DECISION NOTICE

Application Ref: LU/312/14/HH

13 Irvine Road
Littlehampton
BN17 5LB

Raise height of existing front boundary wall.
This application may be determined under delegated powers by Littlehampton Town Council.
This application affects the character and appearance of the Littlehampton Seafront Conservation Area.

DRG No 945-2 A

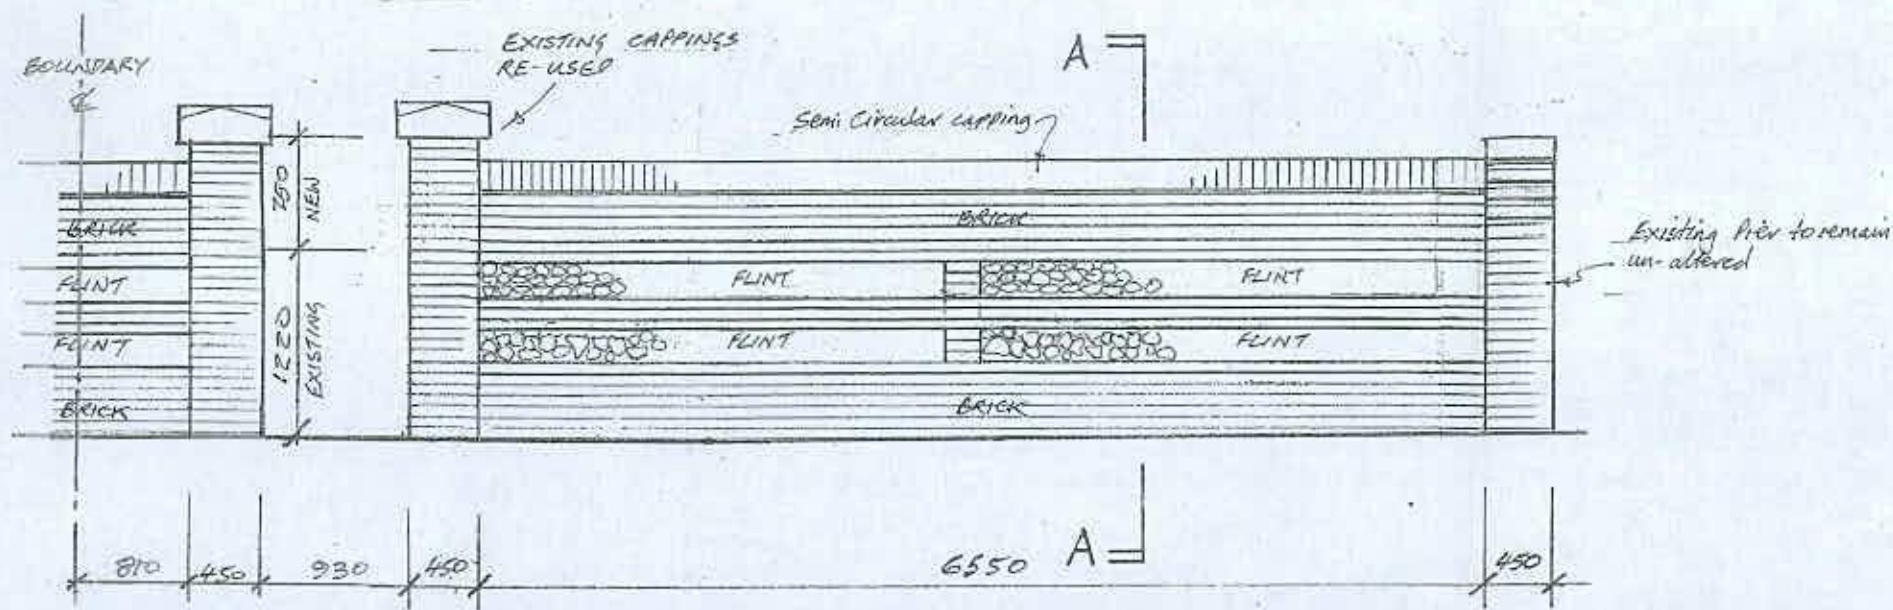
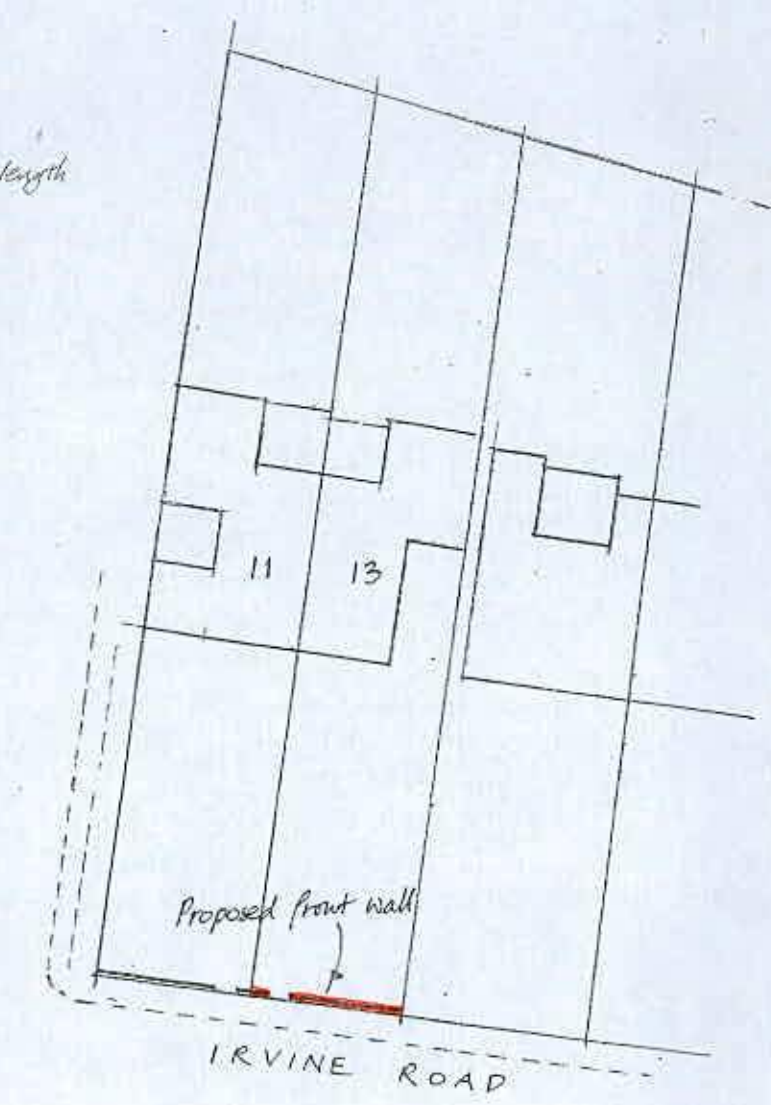
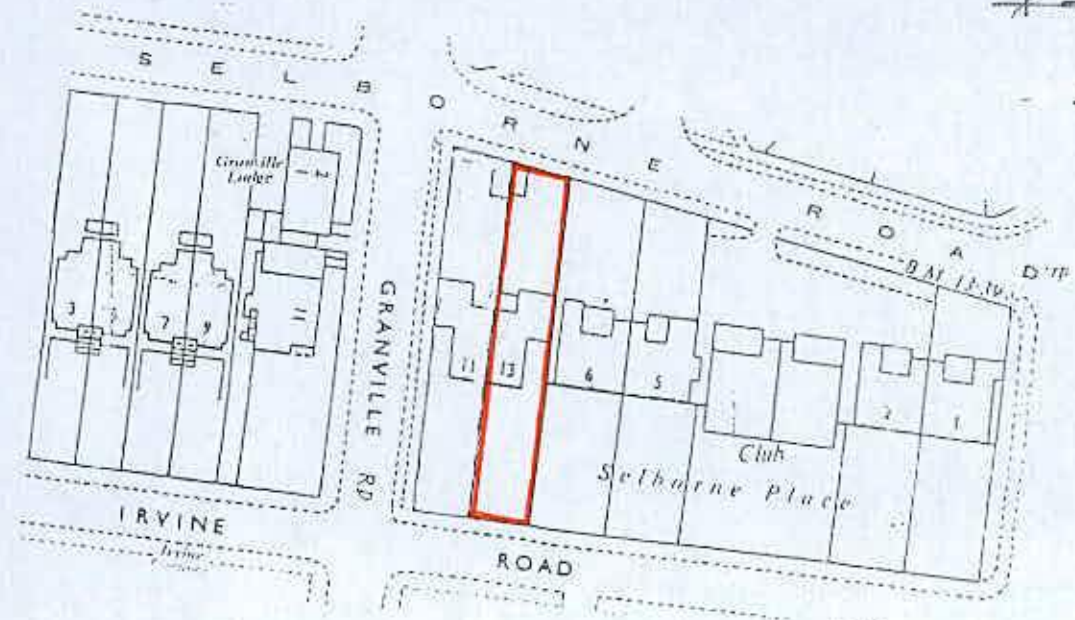
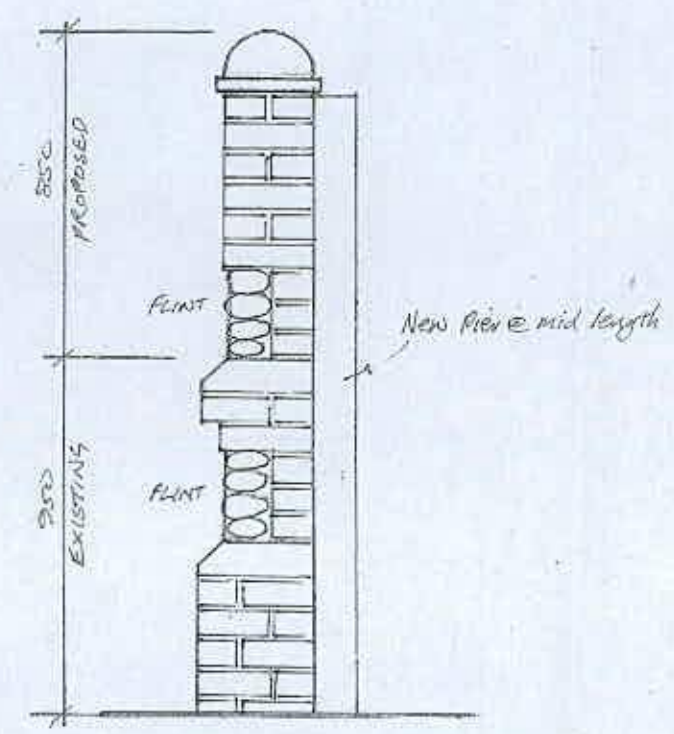
- 1 The proposed increase in height of the existing front boundary wall fronting Irvine Road will have an unacceptable prejudicial impact on the character and appearance of the area and will not preserve or enhance the character and appearance of the Conservation Area in conflict with policies GEN7 and AREA2 of the Arun District Local Plan.
- 2 Based on the submitted information the Local Planning Authority is not satisfied that the structural integrity of the wall is adequate and the proposal therefore conflicts with policy GEN7 of Arun District Local Plan.
